September 18, 2024

Re: Nusenda Credit Union
2801 Juan Tabo Blvd. NE
30-Day Temporary Certificate of Occupancy
Transportation Development Final Inspection
Architect's Stamp dated 10-26-22 (H21-D020)
Certification dated 09-12-24

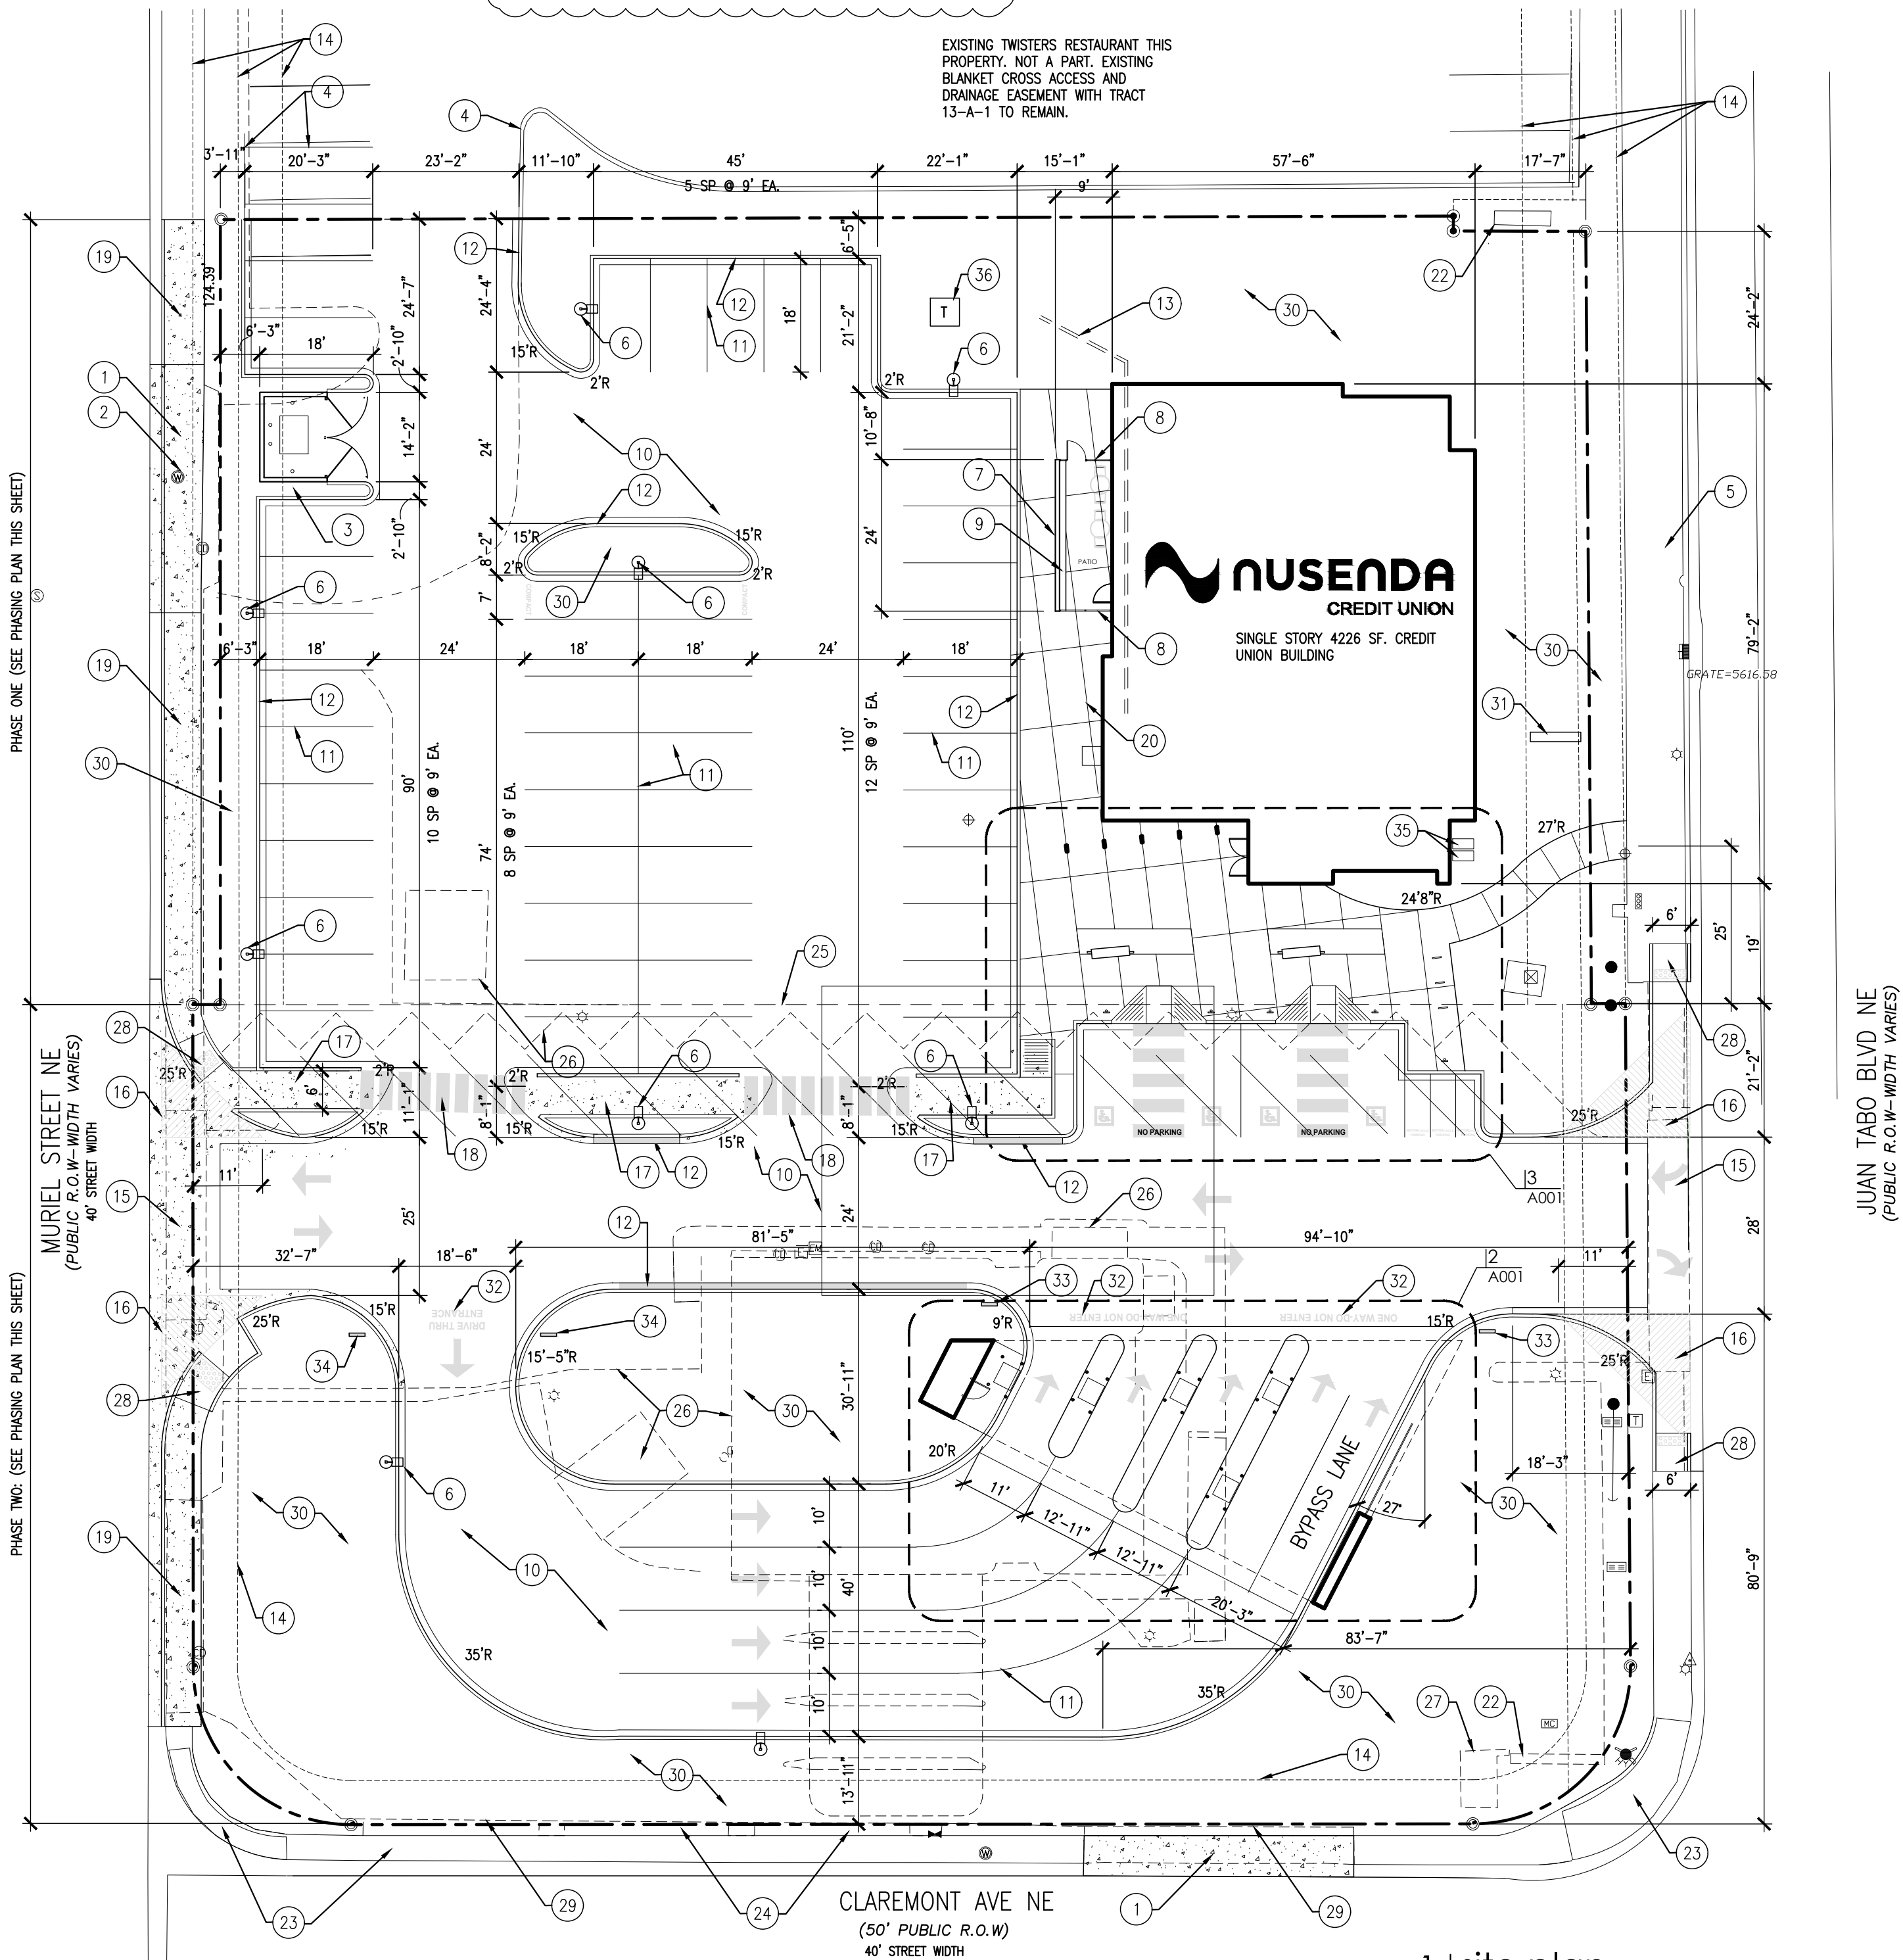
- A Truncated Domes must be installed at the corner ramp of Juan Tabo Blvd and Claremont Ave.
- The city right of way ramp at the corner of Claremont Ave and Muriel St. must be updated to the current ADA standard and truncated domes must be installed. Per site visit the corner ramp width was 3 ft. the minimum width should be 4 ft.

- Prior to issue a Perm CO, the construction of the site access off Muriel St. must be completed.

- Per approved site plan, Unused curb cuts must be replaced with sidewalk and curb & gutter. A build note must be provided referring to the appropriate City Standard drawing.

- Per approved site plan “All broken or cracked sidewalk must be replaced with sidewalk and curb & gutter.” A build note must be provided referring to the appropriate City Standard drawing. Broken sidewalk off Juan Tabo must be fixed.

- Anchor down bike rack.
- Motorcycle parking signs must be installed.
